Subject: FW: BR/29/20/DOC - 34 & 36 Southdown Road, Bognor Regis

BR/29/20/DOC - 34 & 36 Southdown Road, Bognor Regis PO21 2JR

Further to your request please find attached amended drawings 1926 P 01 Rev A incorporating an Electric vehicle parking bay and charging point.

block plan

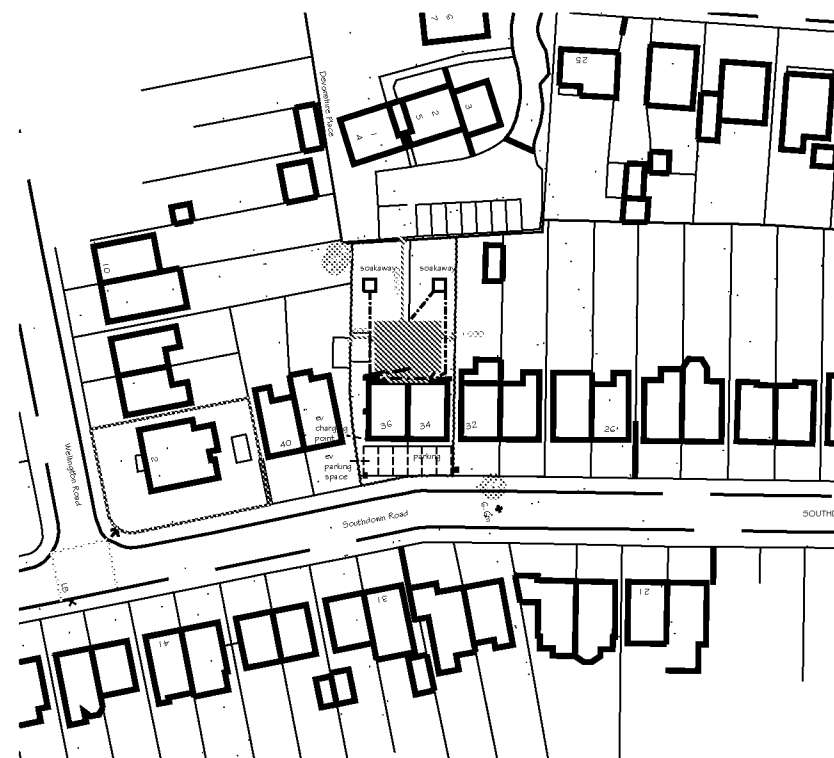
The only outstanding/further piece of information I will require is in relation to condition 6 (EV charging). To be able to discharge this I will need to see a site plan showing the location of the EV plug and which spaces these will serve. Please note that the number of spaces to be served will need to accord with the Arun District Council Parking Standards Guidance found online, for me to be able to discharge this. If you could provide this at your earliest convenience I would be most appreciative?

We understand the provision for flats is one parking bay per 2 % of the parking spaces provided.
